APPLICATION NO. 06DPB-01344	PROJECT NO. <del>XXXXXX</del>
PROJECT NAME LOT 30 TRACT A	
EPC APPLICATION NO.	
APPLICANT / AGENT WENDELL JONES	PHONE NO. 823-9452
ZONE ATLAS PAGE C-18	
(SDP for SUB), (SDP for BP), (FINAL PLATS), (MASTER DEV PLAN), (IR) (AA)

# ONE STOP COMMENT FORM LOG

DESCRIPTION OF REQUEST: Review & approval of document(s) related to development of 5301 Eagle Rock NE, Alb.

SITE/LANDSCAPE PLAN

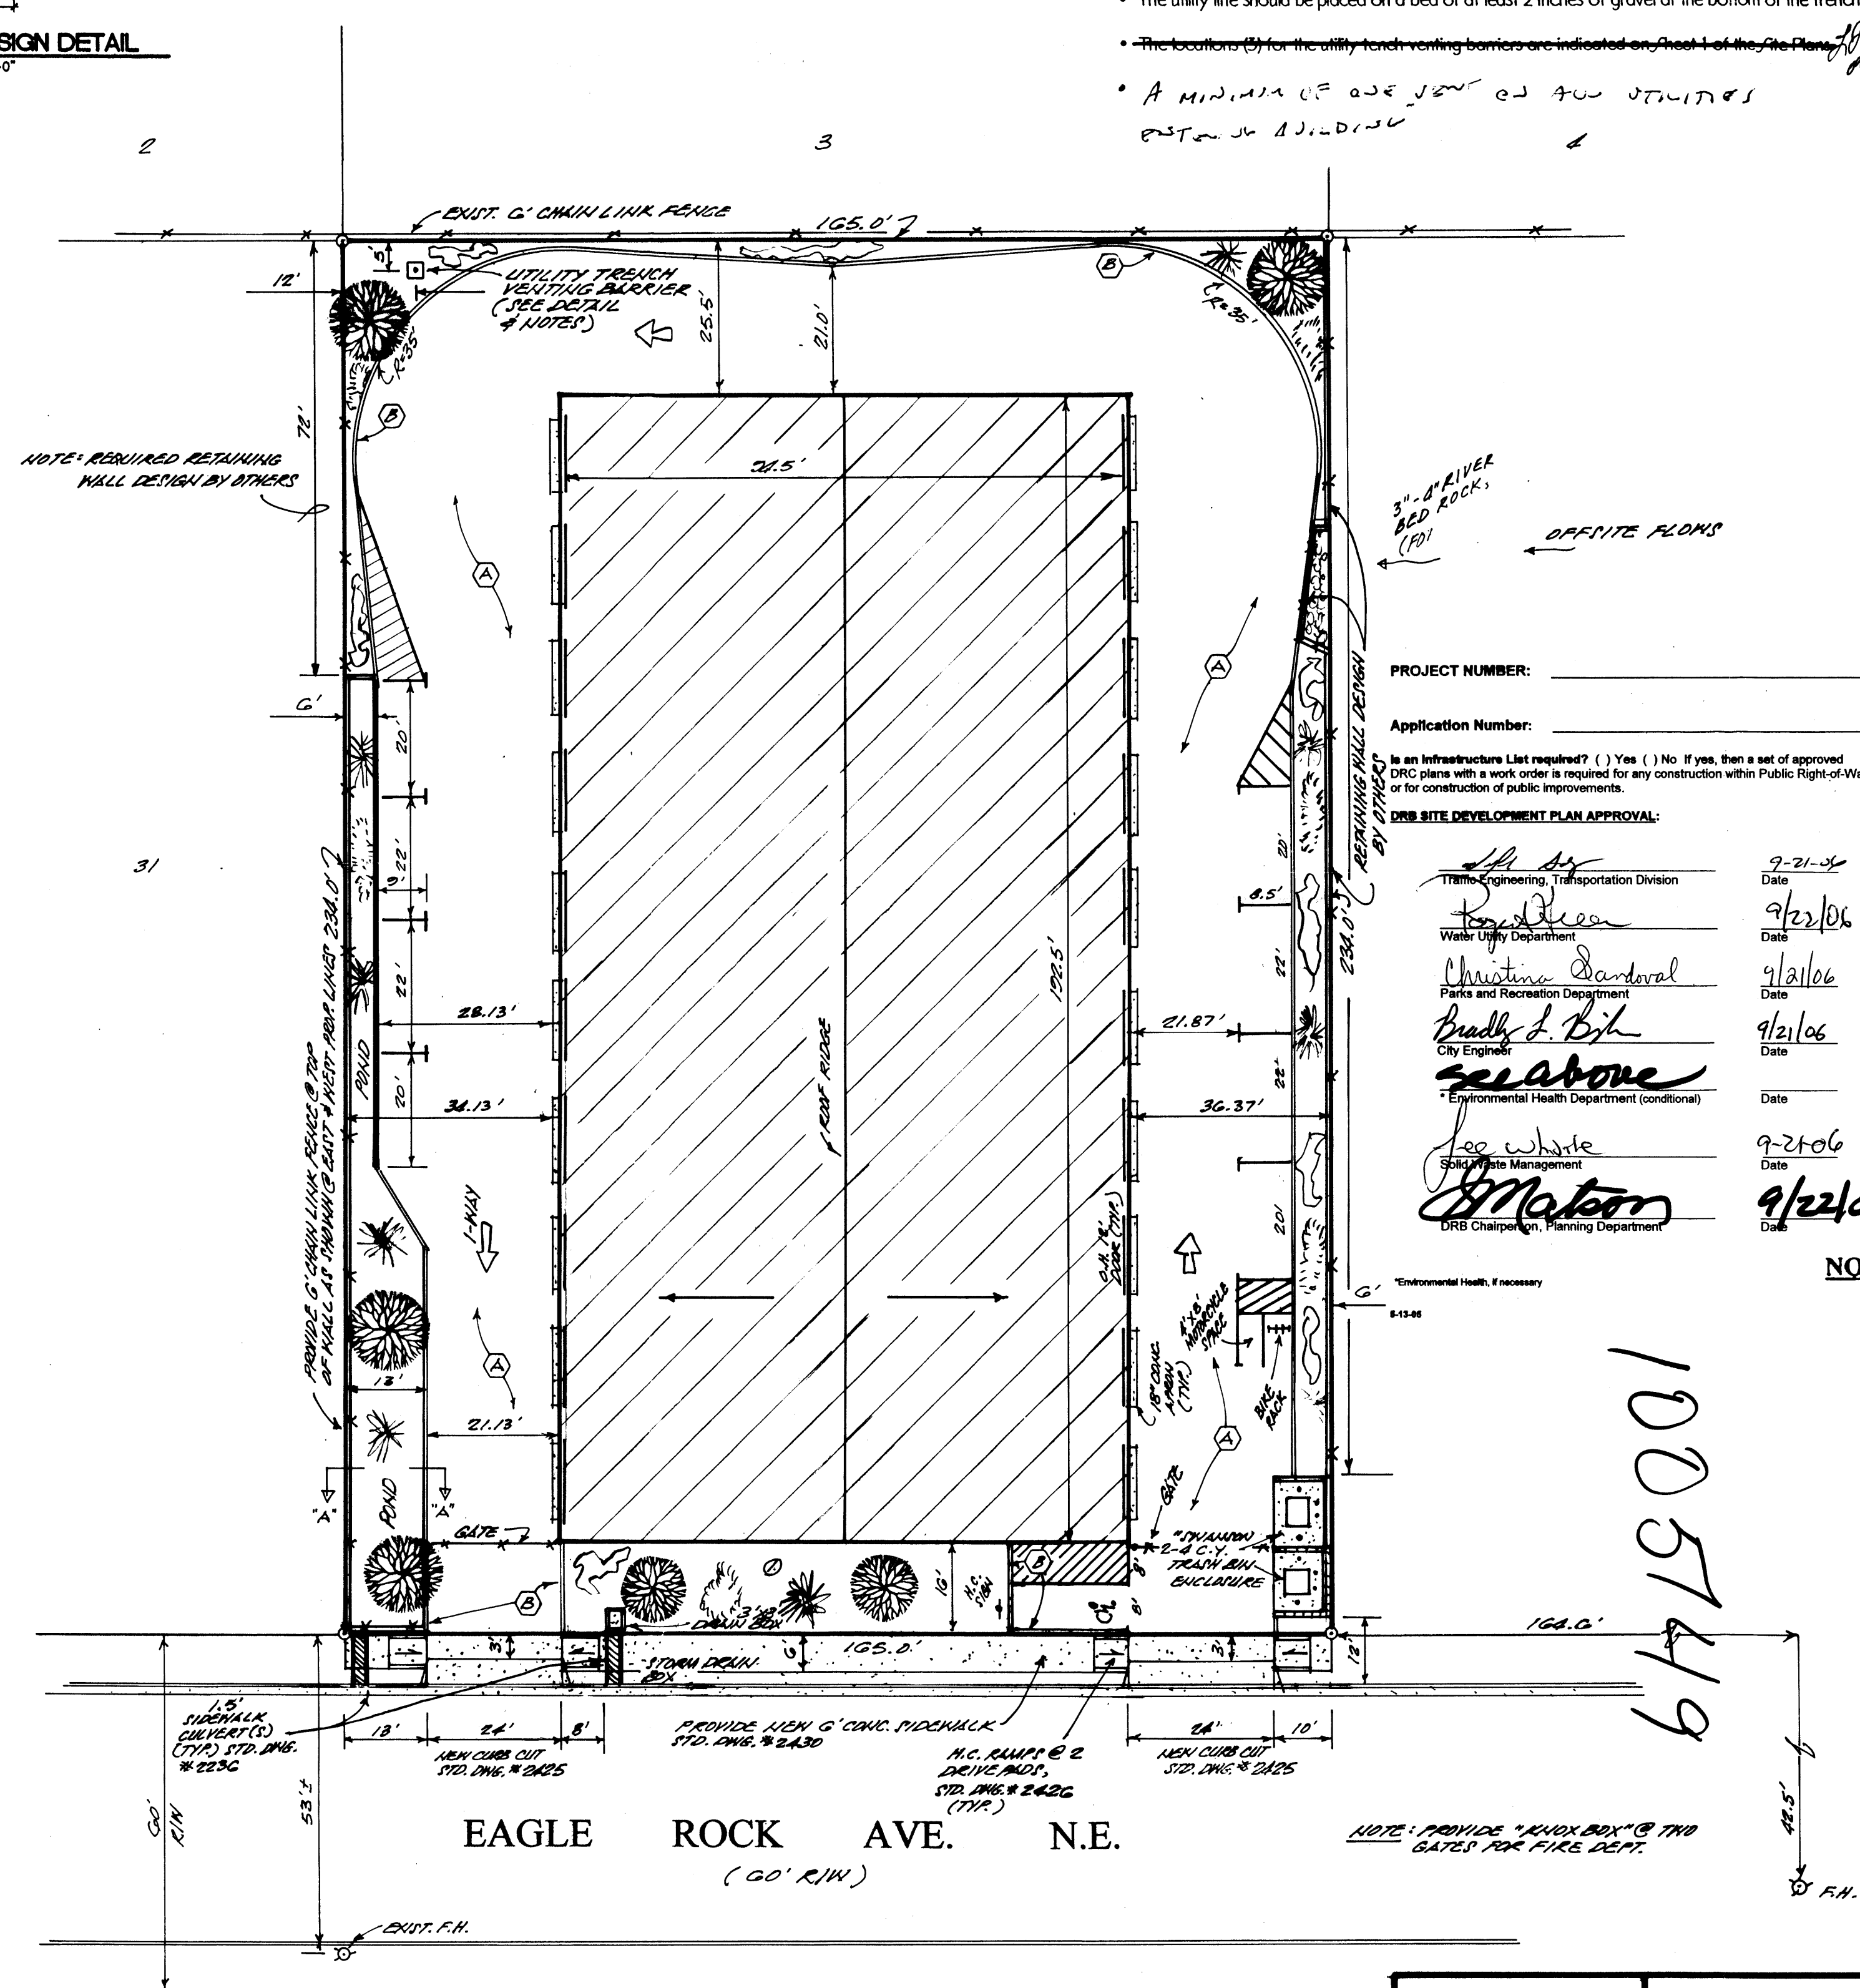
UTILITY DEV (505) 924-3989			
PLANS DISAPPROVED <b>RRR</b>	DATE 9/12/06	DATE	DATE
PLANS APPROVED <b>RRR</b>	DATE 9/21/06	DATE	DATE
COMMENTS:			
Need Fire Marshall Approval and site plan. must show existing fire hydrants. Also Need Fire Flow calculation sheet from Fire Marshall.

TRANSPORTATION DEV (505) 924-3990			
PLANS DISAPPROVED <b>W/G</b>	DATE 9-12-06	DATE	DATE
PLANS APPROVED	DATE	DATE	DATE
COMMENTS:			
<del>SEE</del> COMMENTS FROM TCL SUBMITAL!			
- NEED SIGNATURE BLOCK.
